SCOPING OPINION:

Proposed A46 Newark Bypass

Case Reference: TR010065

21 October 2022

**Figure 2.4 Locations of Temporary Works Areas Required During
Construction**

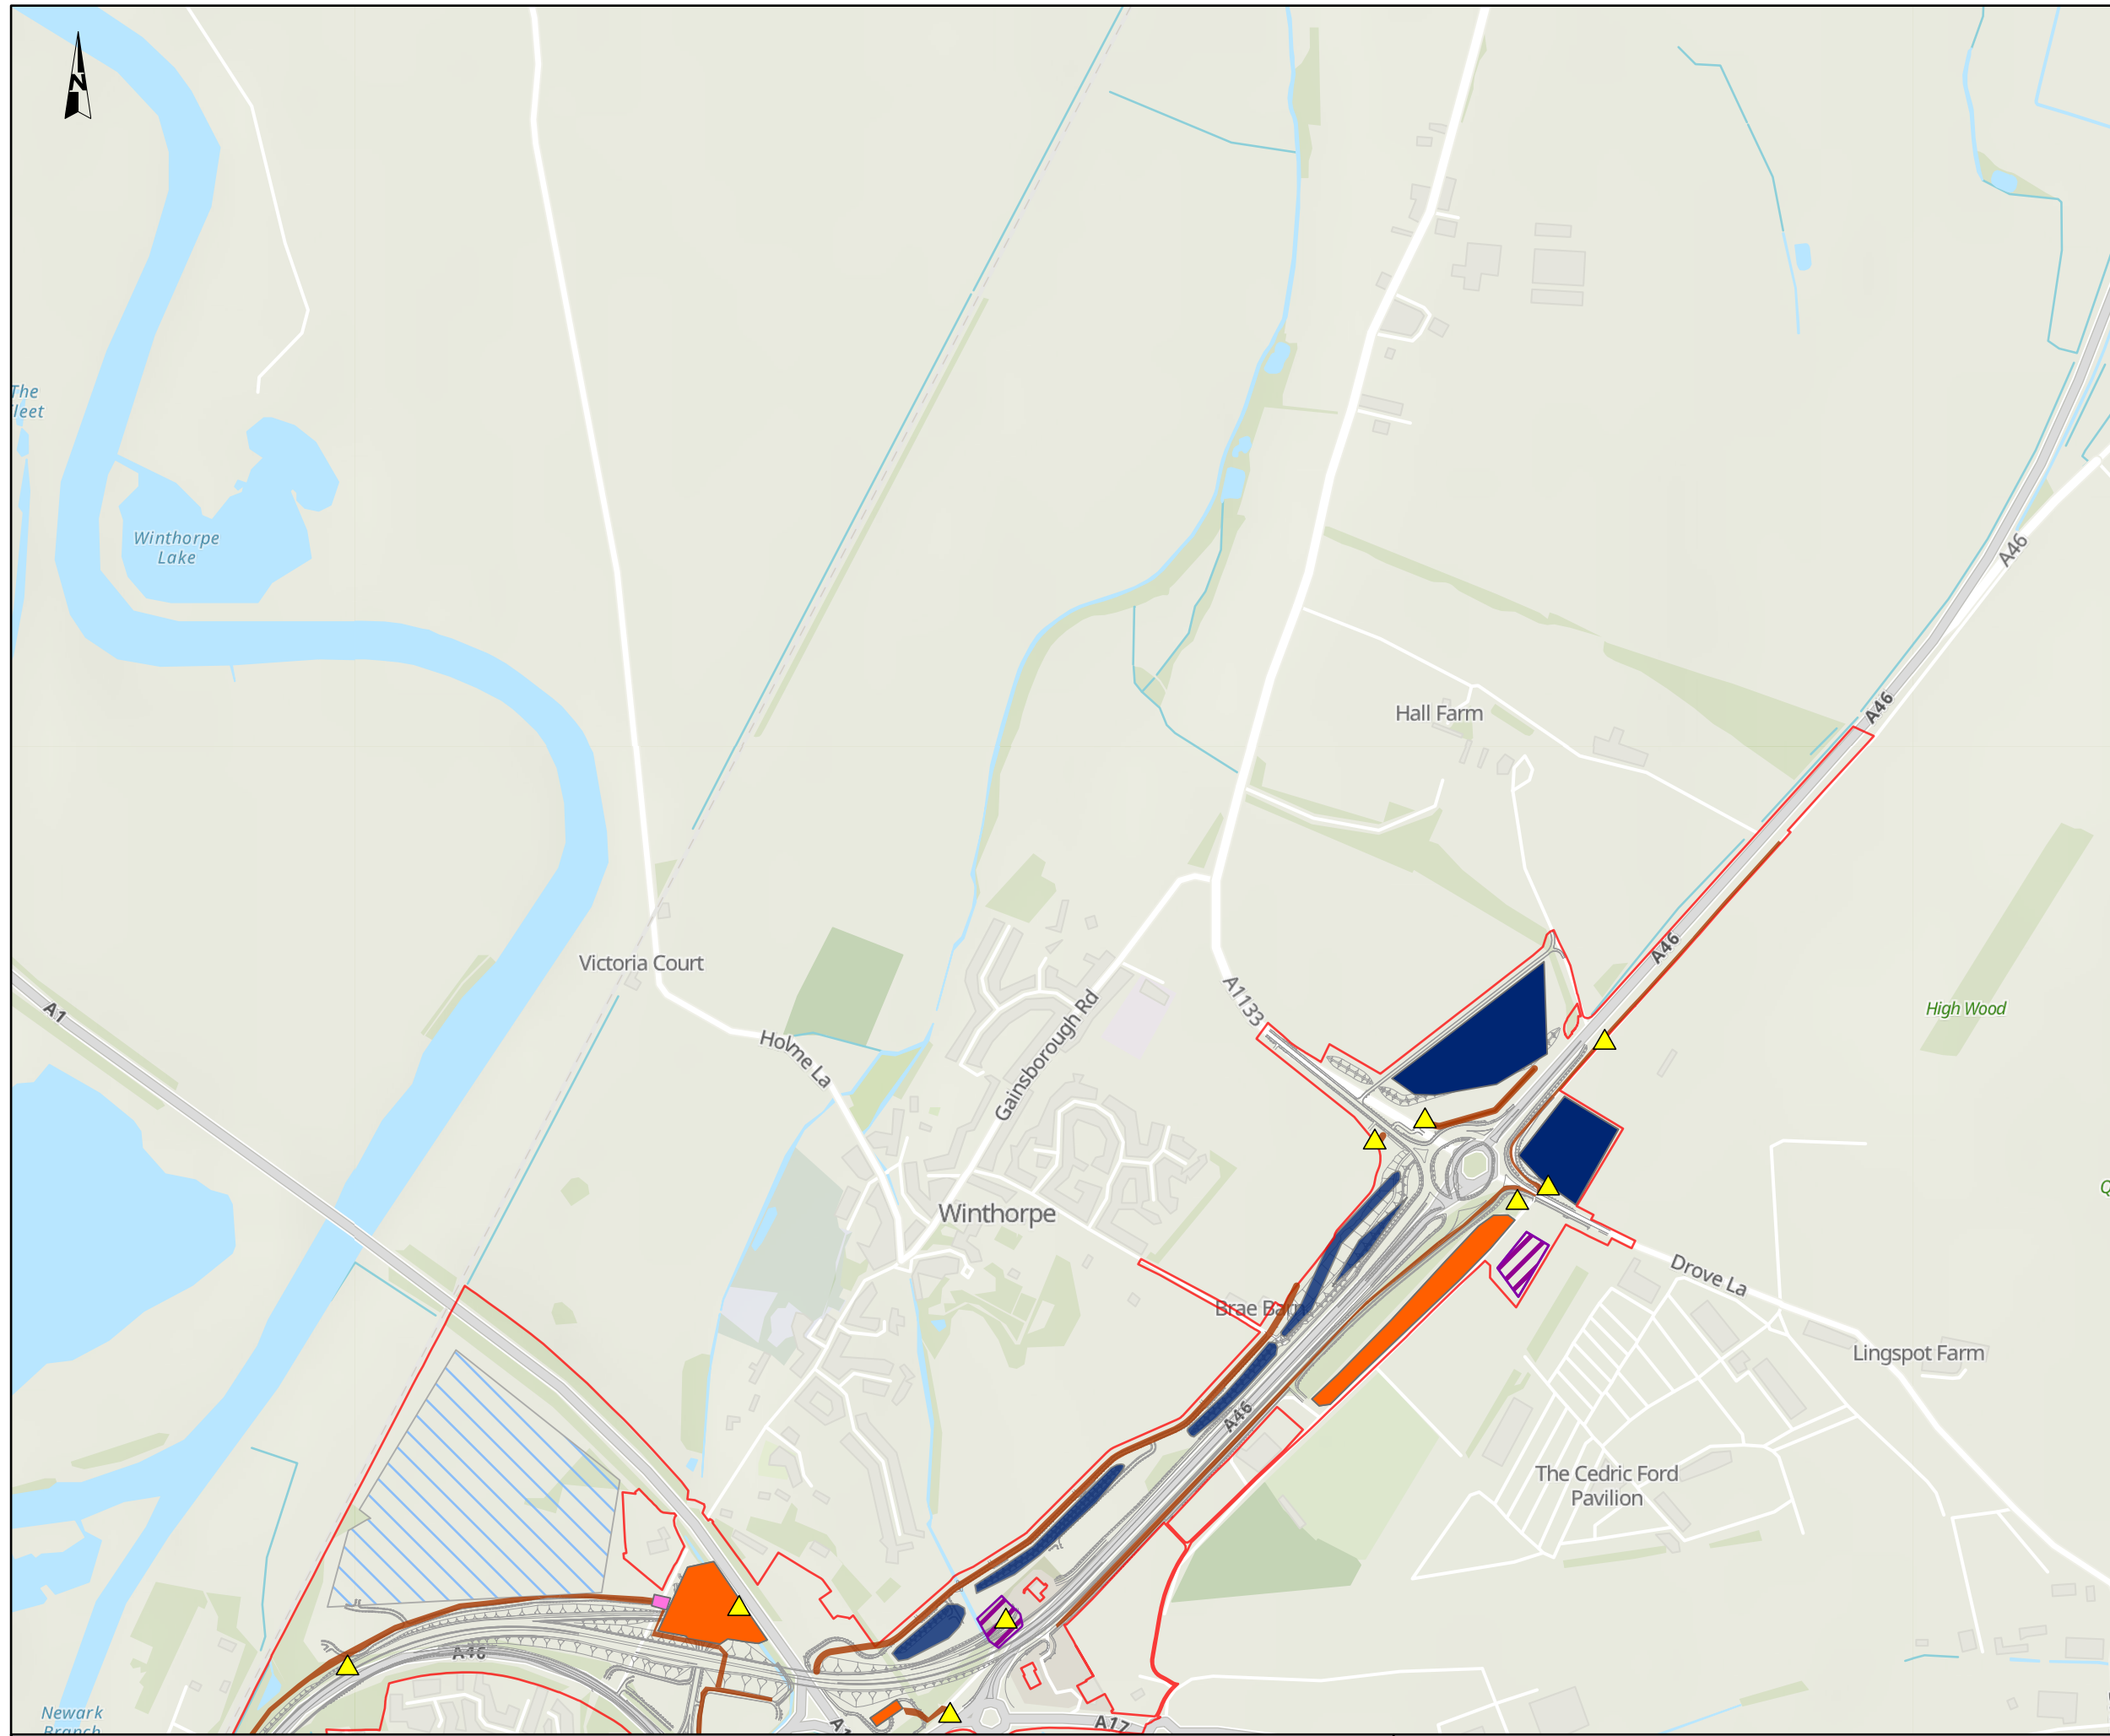
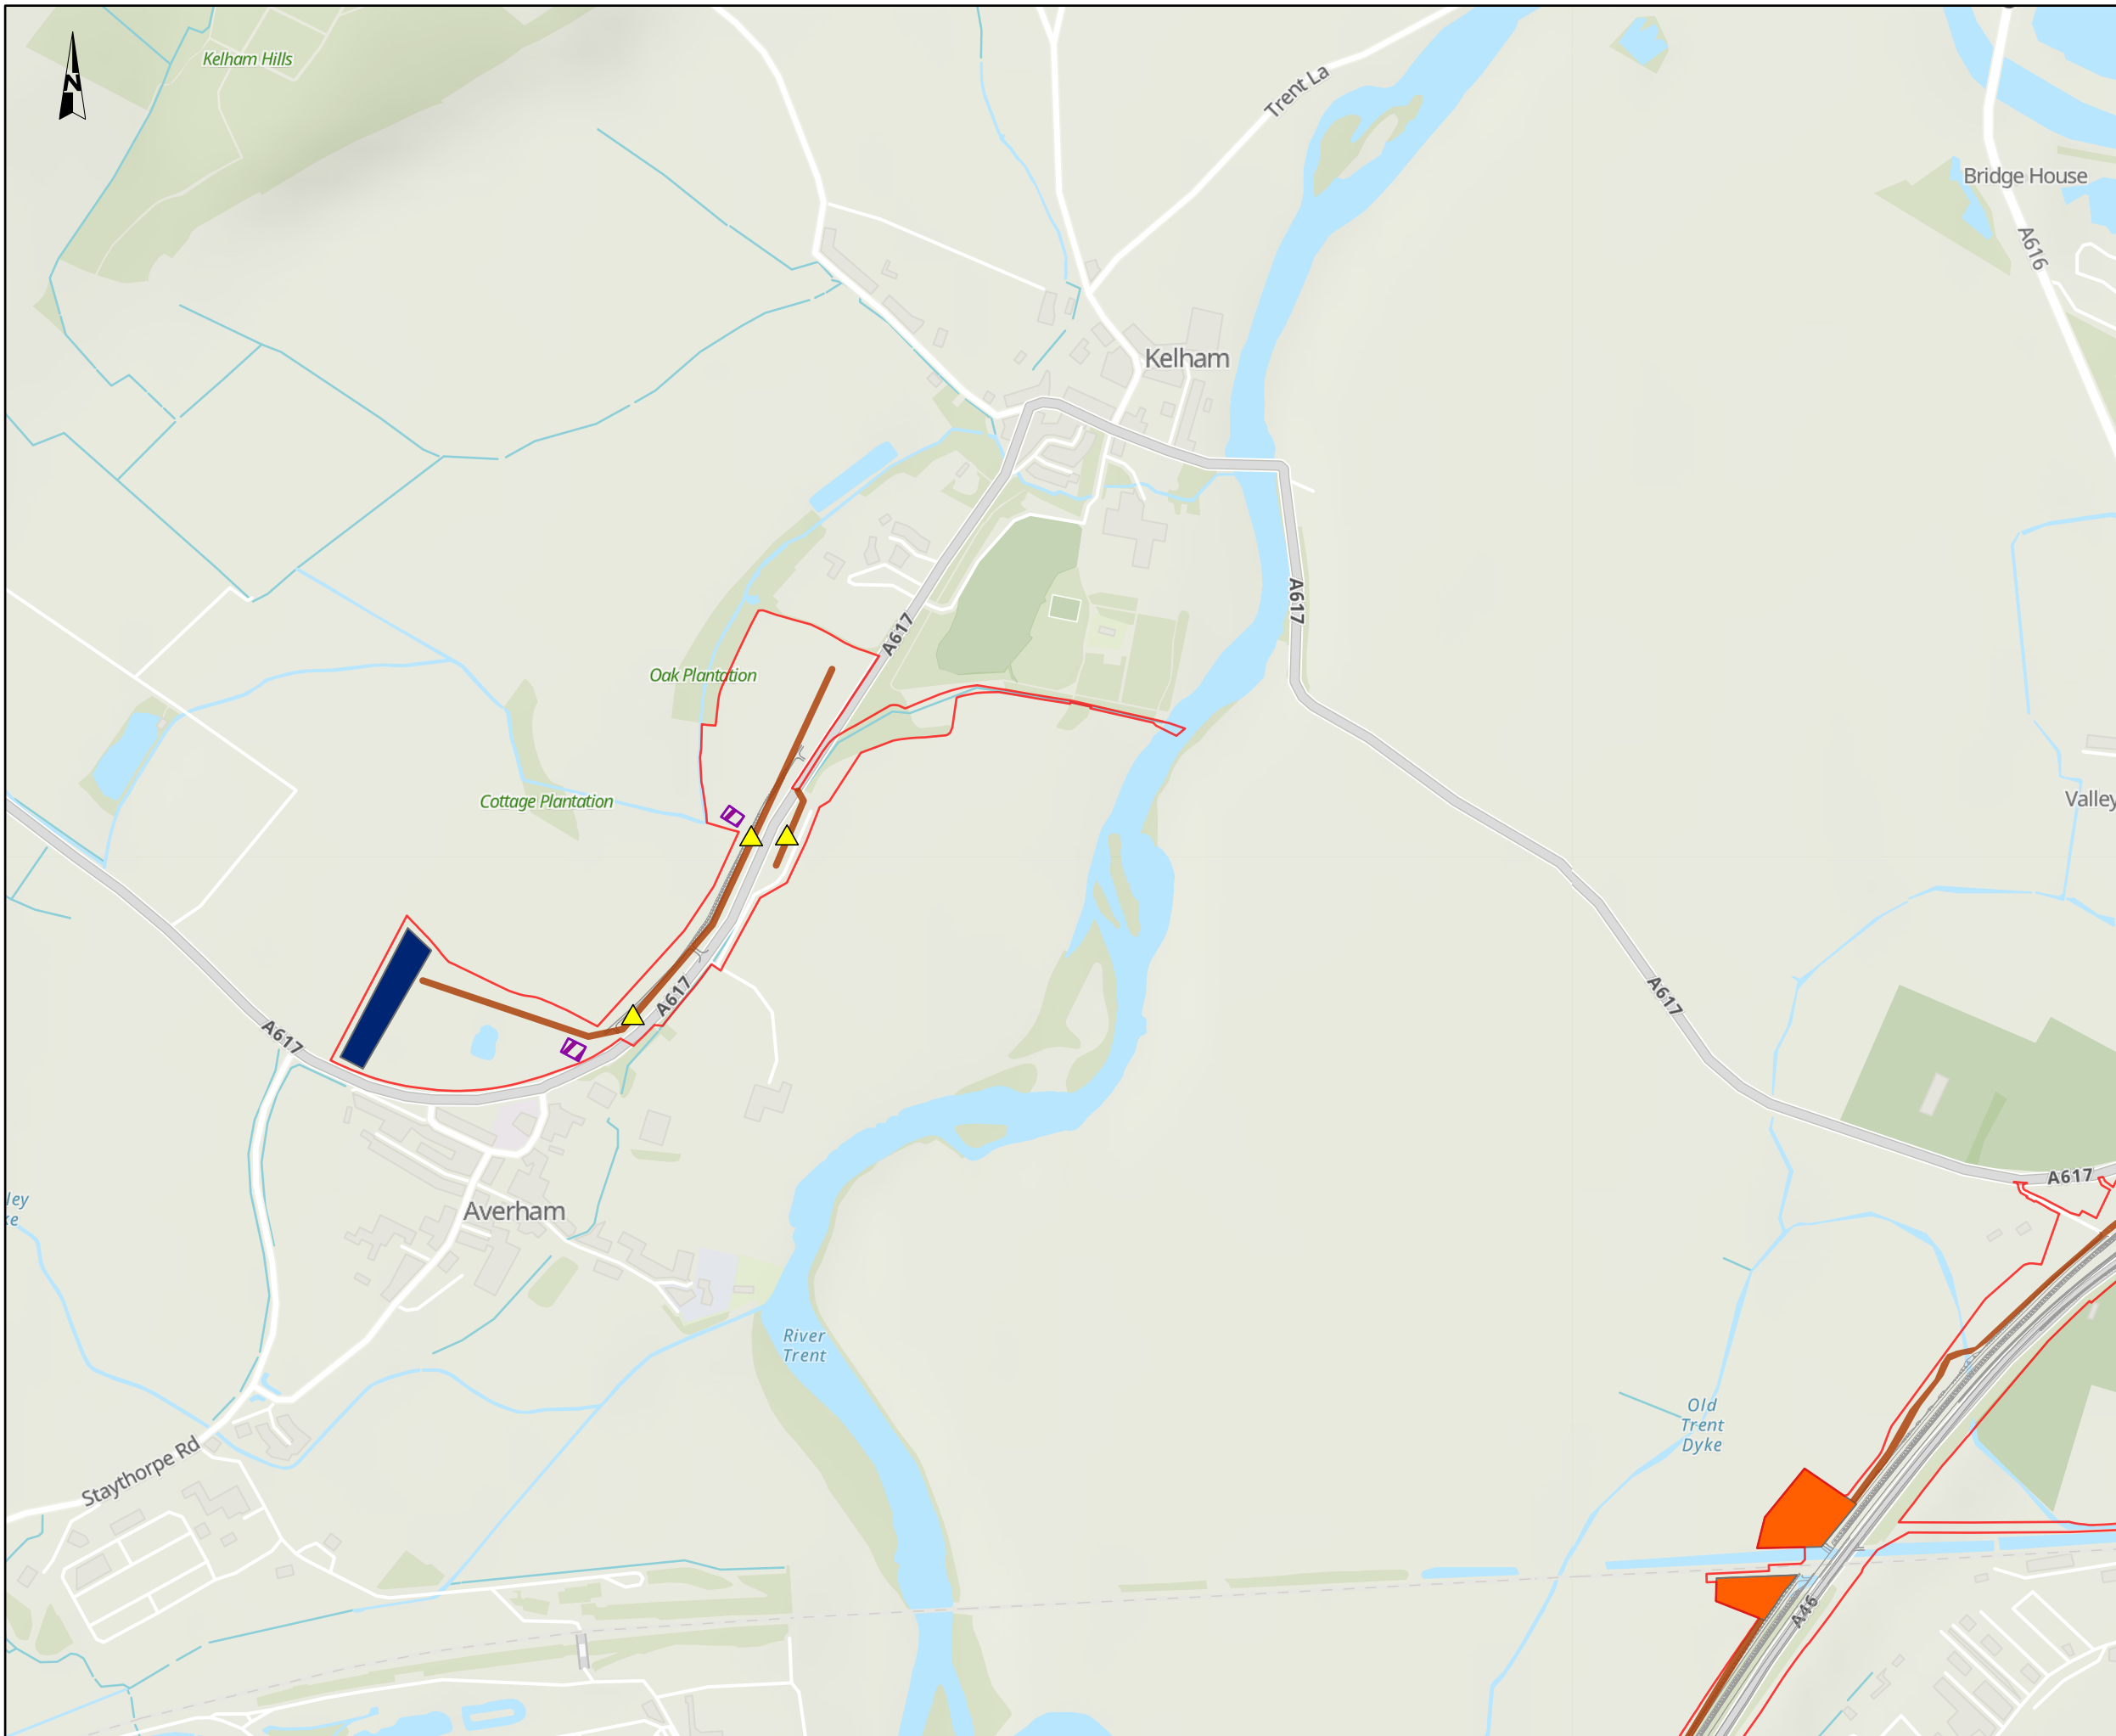
ID	Ref	Description	Inspectorate's comments
3.8.8	n/a	Temporary Works Areas and construction compounds	The Environmental Constraints Plan shows a number of areas identified as Temporary Works Areas. It is noted that these areas are located in Flood Zone 3. Furthermore, the Scoping Report states that construction compounds will be located outside of Flood Zones 2 and 3, however, it appears from the Environmental Constraints Plan that the indicative location for the main construction compound is located in Flood Zone 2 or 3 (not clear to see due to scale used) as are a number of proposed satellite construction compounds. The ES should provide further information regarding the nature of works required in these areas and contingency measures to be implemented if the areas became unavailable in times of flooding.
